Our Reference: NS212832
DPHI's Reference: SSD-96248991:

Re: Rouse Hill Hospital – HI24498

In relation to the Hills Shire Council's comments on the Civil Design for SSDA Design for the new Rouse Hill Hospital d Corner of Commercial Road and Windsor Road, Rouse Hill) as shown in the below table:

DESIGN LEVELS

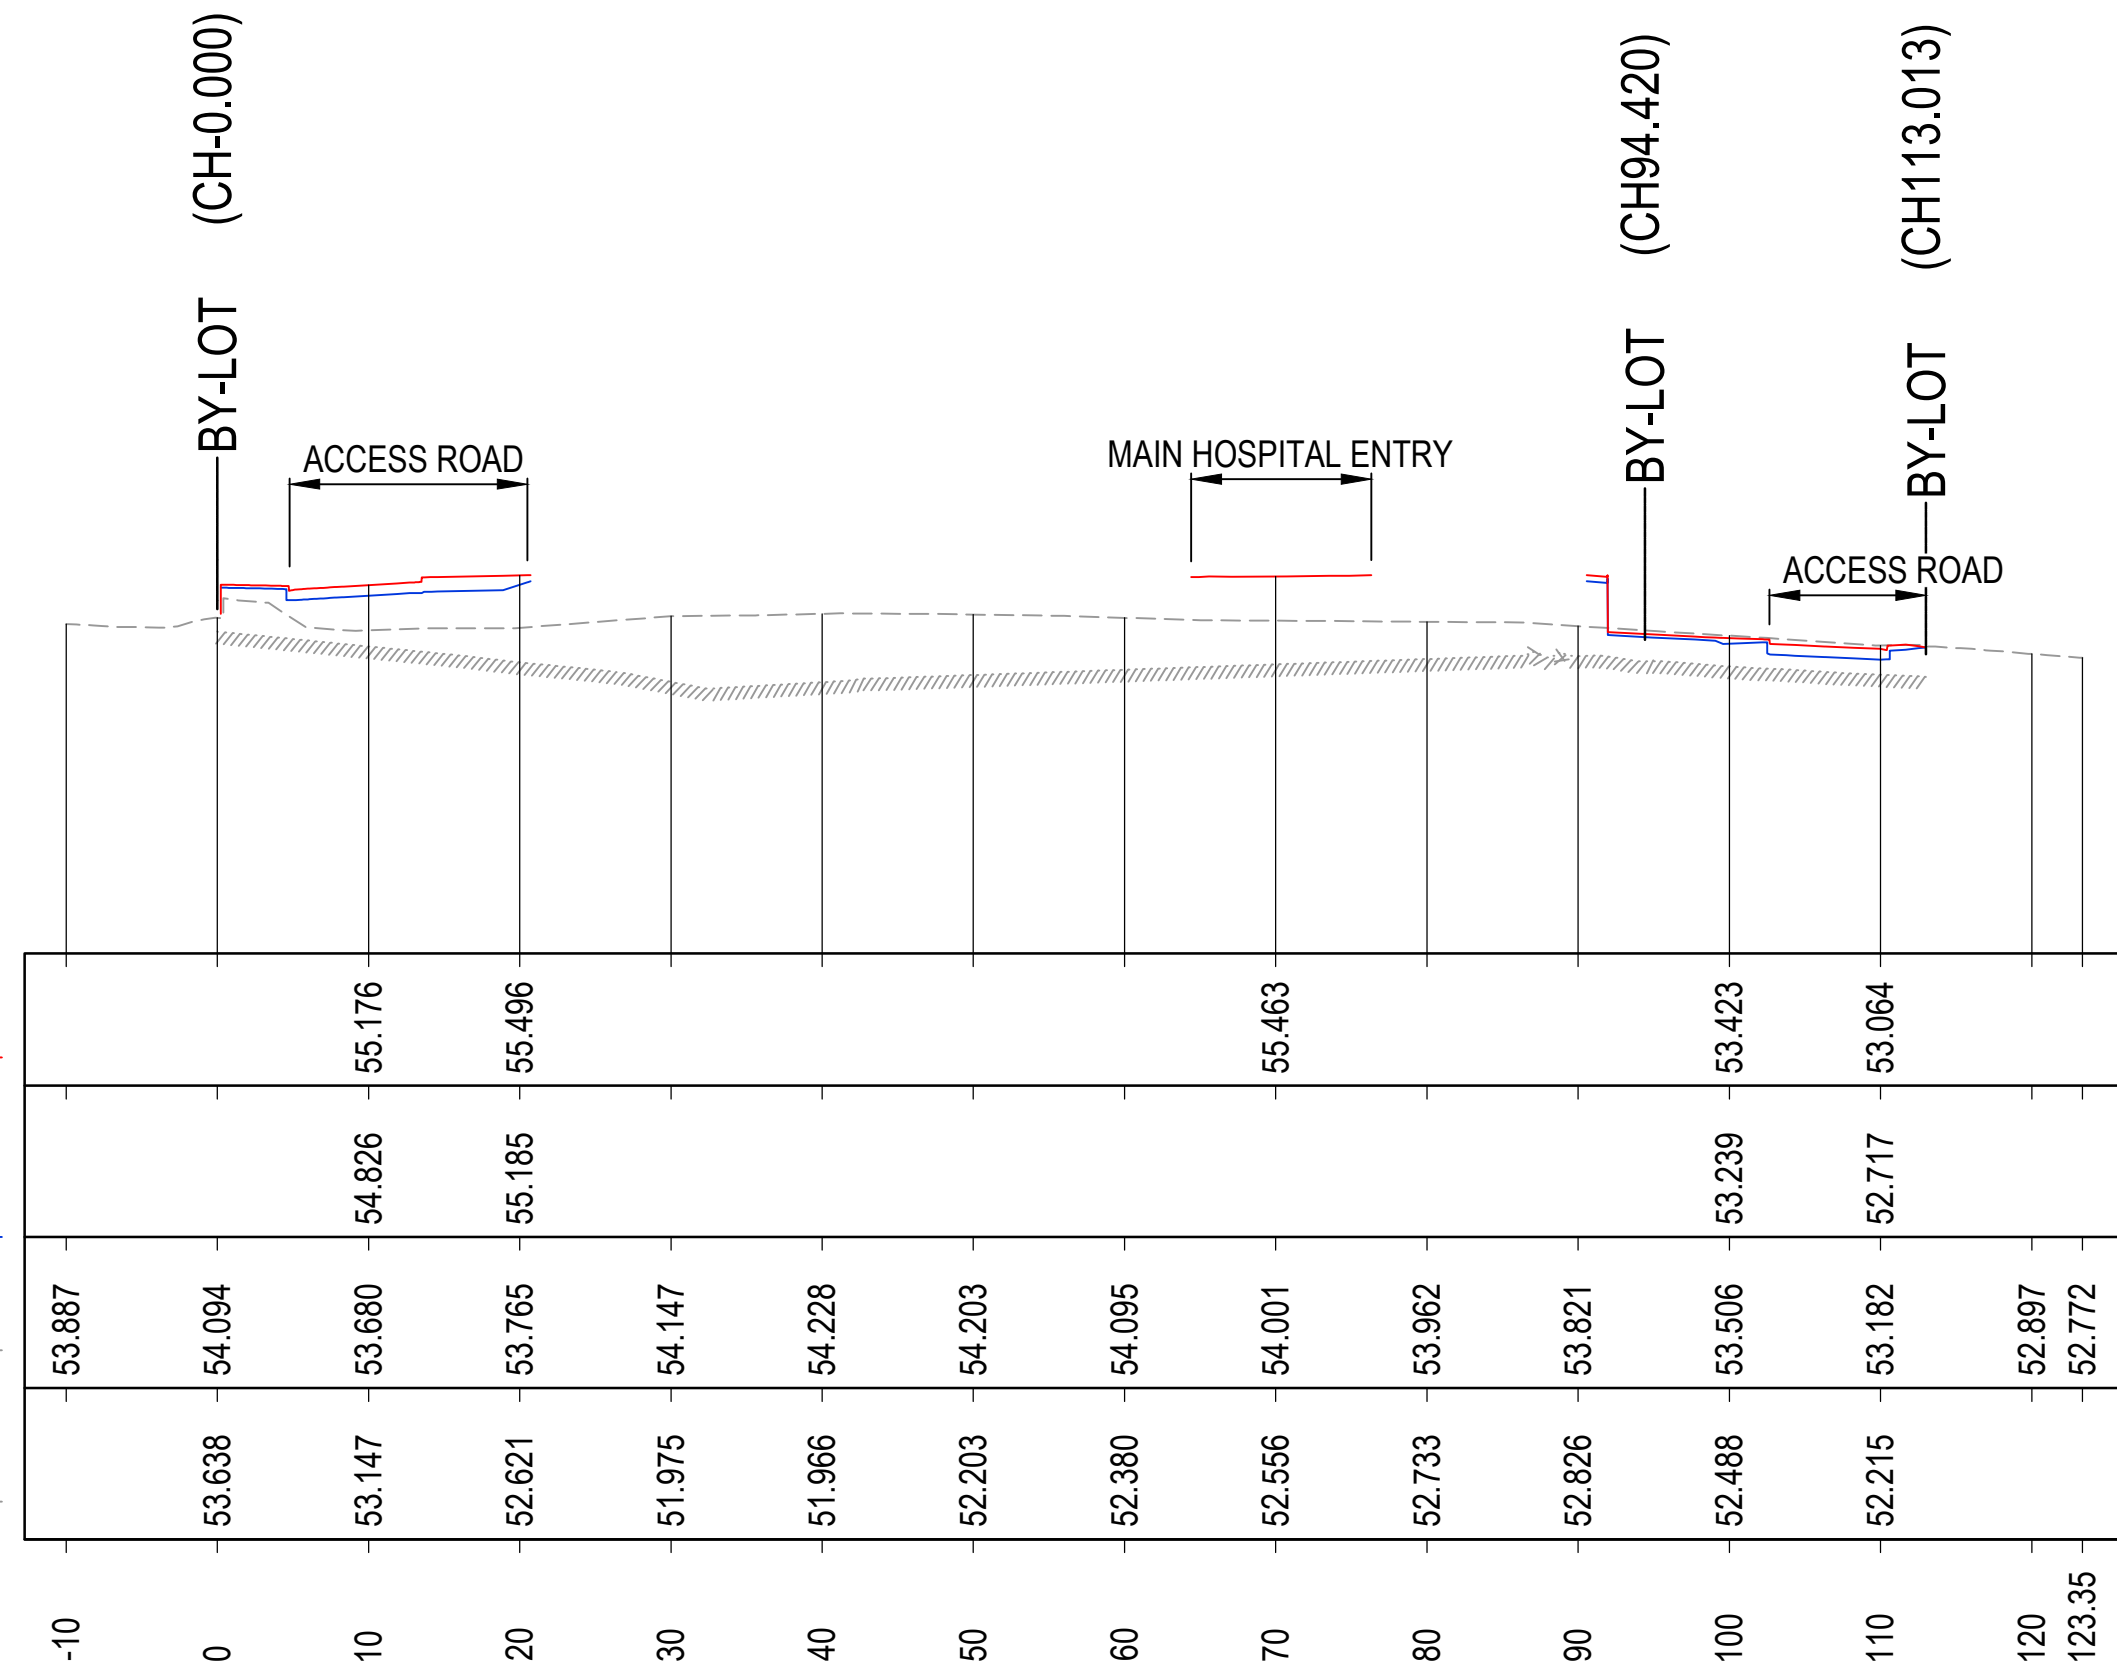
Submission	Themes	ACOR Response
<p>kerbs, gutters, footpaths, final road build up and surface are not included in early works and are shown only for information” the future surface levels can only be vary by 100mm or less is required to be clarified. The surface level will be fixed by this Development Application approval hence the earthwork plan, cut and fill, and retaining wall (including ToW, BoW, long section) shall be provided on a separate plan any batter shall be 1:4.</p>		<p>However, the civil constructions work is split into two different packages Early Works and Main works design packages. Each package will capture different civil elements as the following:</p> <ol style="list-style-type: none"> 1- Early Works design package: this will capture mainly the temporary construction access roads and main works stormwater drainage network including underground on-site detention basin (OSD). Installation of this OSD has been approved under a Part 5 (REF) approval. 2- Main Works design package: this will capture main roads pavement including the kerb, gutter, landscape and footpath. The approval path for Main works State Significant Development Application (SSDA) <p>During the design of Early Works access roads intentionally the finish level adopted to allow minimum earthworks to construct the main works roads by reducing the levels to allow the pavement layers for the main works road.</p> <p>The design has adopted Hill Shire Council and the geotechnical recommendation which allow up to 1V:2H batter slope (refer to Design Guidelines Subdivision/Developments, Table 3.9)</p>

RETAINING WALL ELEVATION - MW01

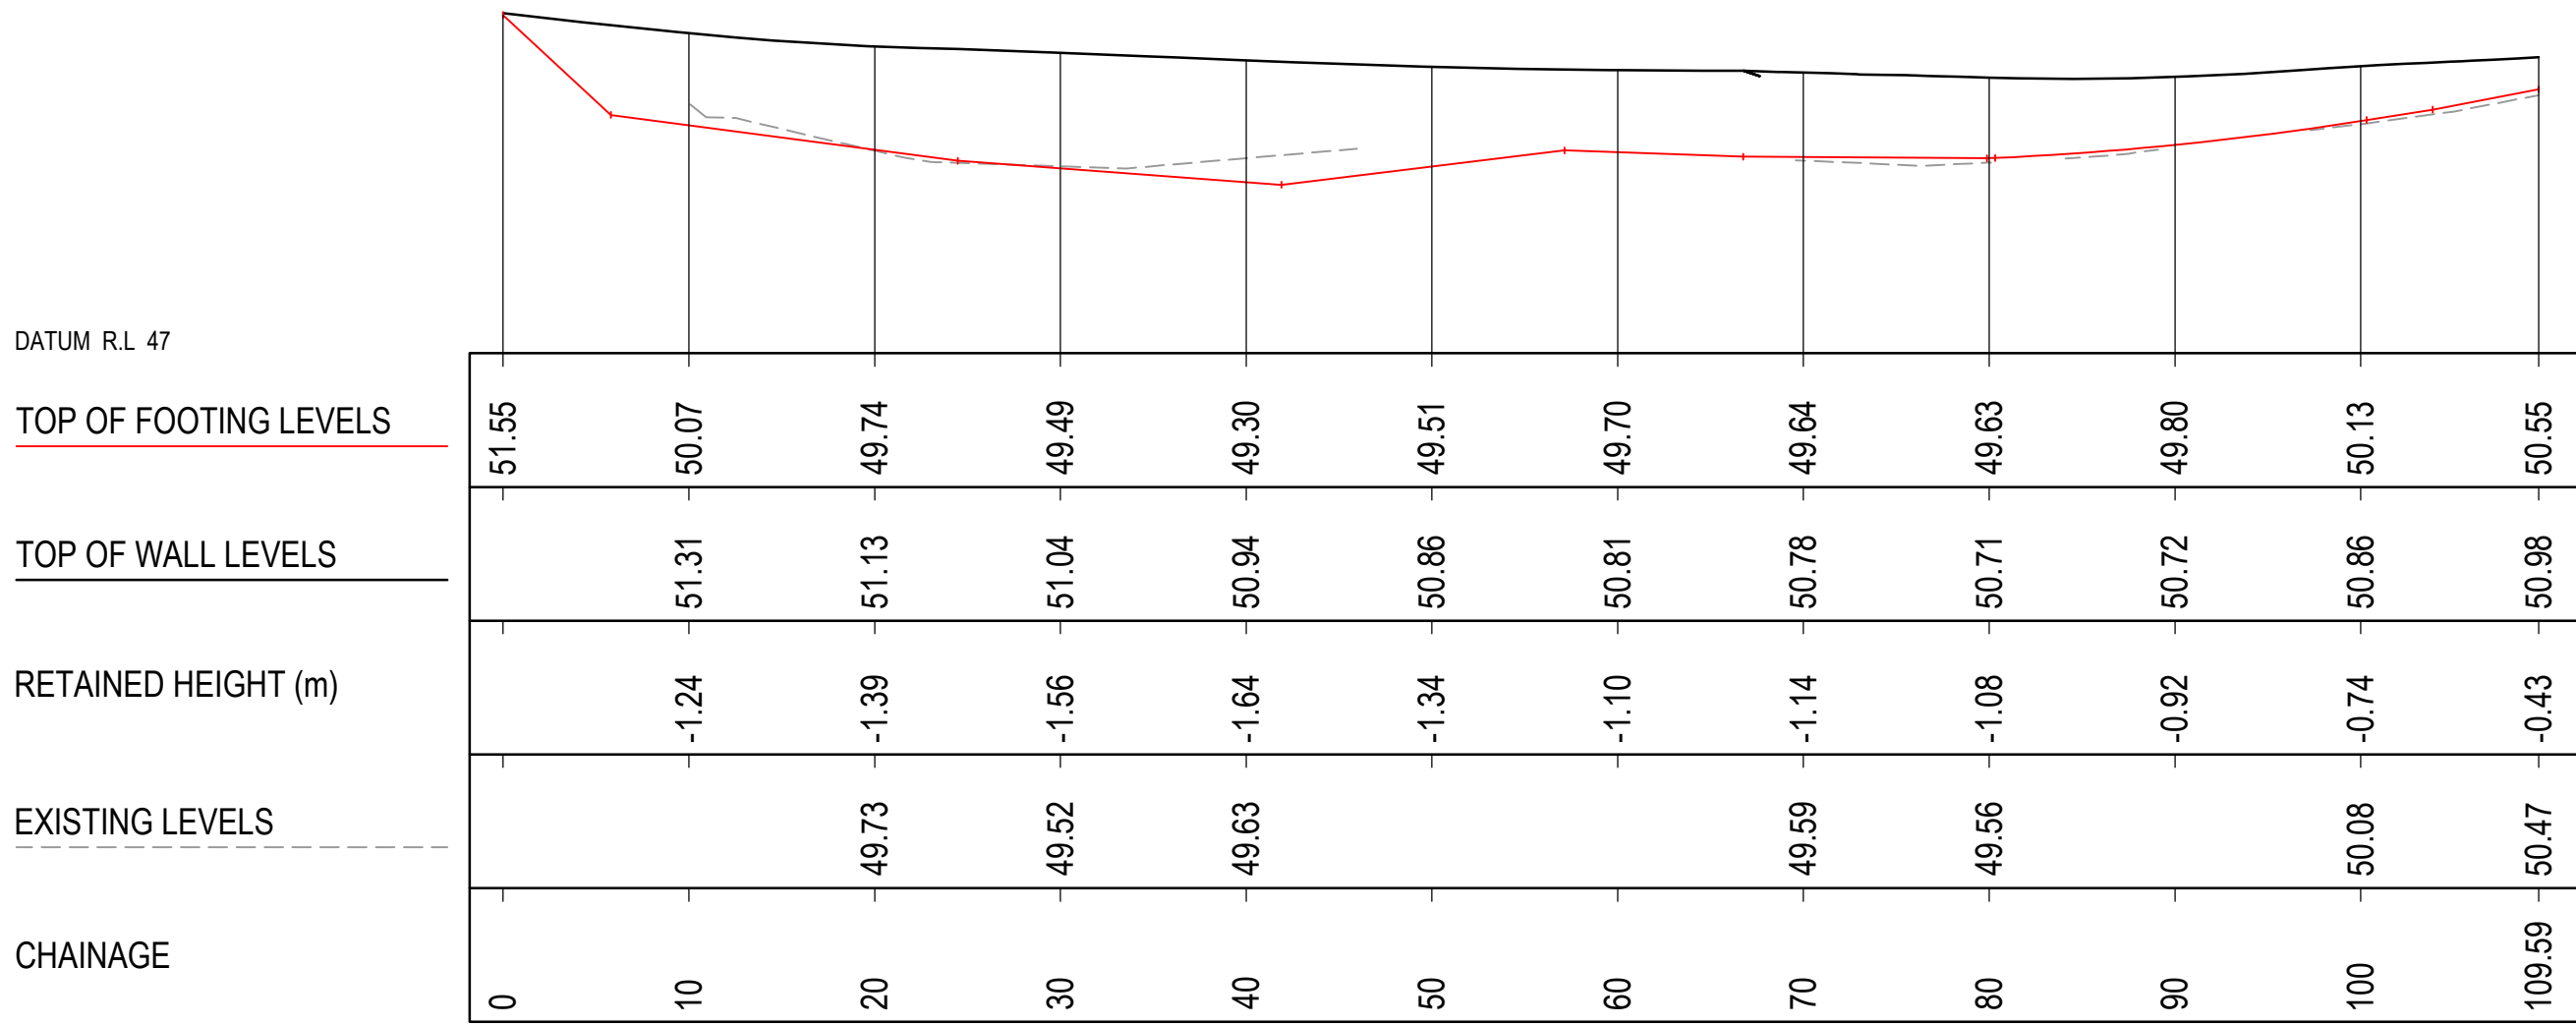
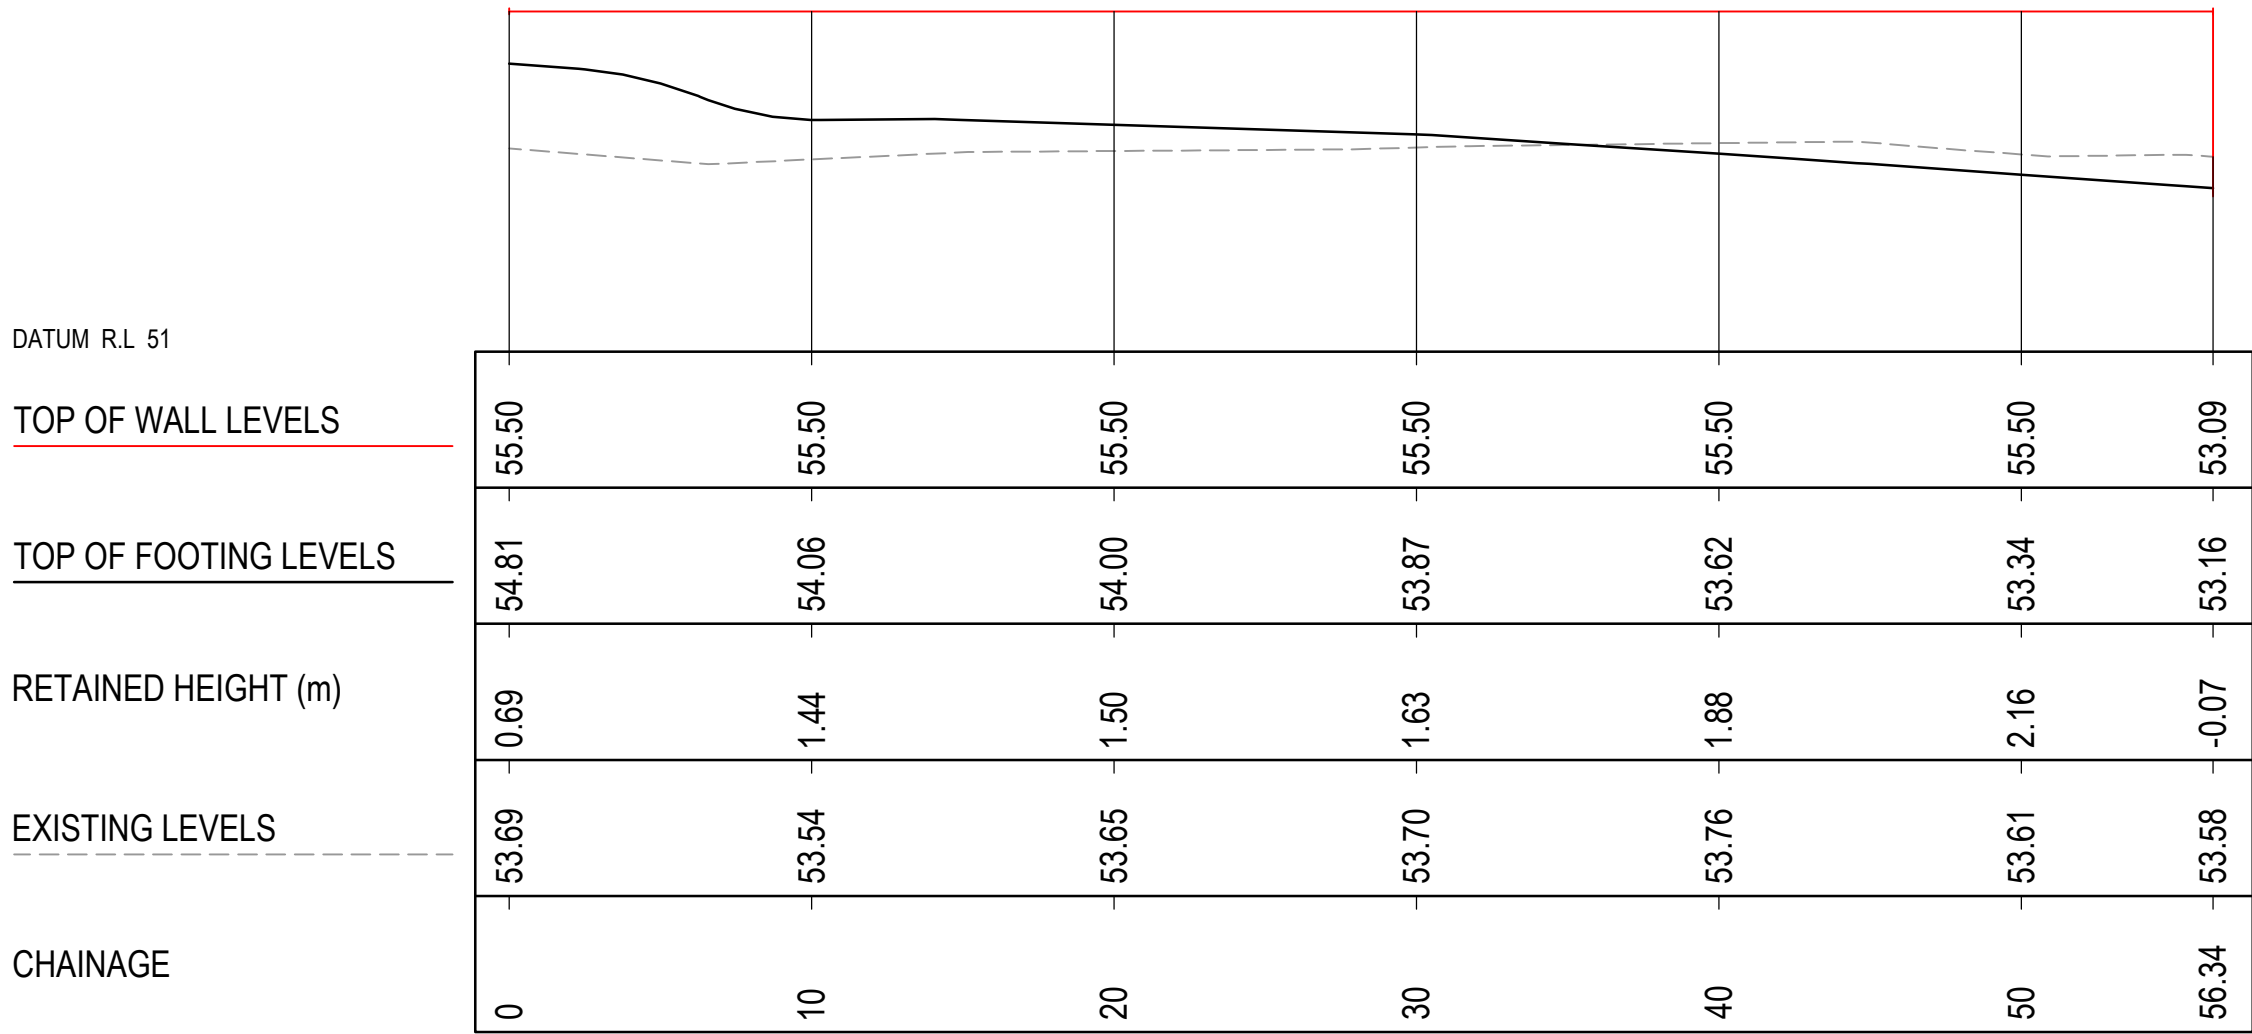
Submission	Themes	ACOR Response																						
<p>Any proposed retaining wall shall be designed such that it accepts and caters for any surface runoff from the up slope adjoining land in a 'failsafe' manner without affecting</p> <p>any other property. No diversion or concentration of stormwater surface flows will be permitted. Any proposed retaining wall including footing and subsoil drain shall be designed and constructed fully inside the property boundary.</p>	<p>Proposed retaining walls</p>	<p>ACOR: The current civil design incorporates measures to manage stormwater runoff within the project site. Overland flow is directed into the nearest proposed drainage pit and through the new stormwater drainage network. Additionally, the structural details of the retaining wall at the project boundary include a subsoil drain for boundary water management.</p> <p>However, during the detailed design phase, a revised retaining wall arrangement may be adopted. If this change occurs and is approved by Endeavour Energy (EE), a surface swale may be required to ensure that no surface flow is directed toward neighbouring properties.</p>																						
<p>Civil Engineering plans shall be prepared and provided as part of the submission. This shall include but not limited to full road's width, long section, cross-section, earthworks, extent of the cut/full, drainage, services, etc. Earthwork plans, cut and fill, and retaining wall shall be provided on a separate plan.</p>	<p>Civil Engineering plans</p>	<p>ACOR: The civil engineering plans submitted for the SSDA (State Significant Development Application) contain the necessary information, as detailed in the drawings list provided below. However, the comprehensive stormwater drainage design for the main works will be subject to a separate approval path (REF), as its construction is scheduled to occur concurrently with the early works phase.</p>
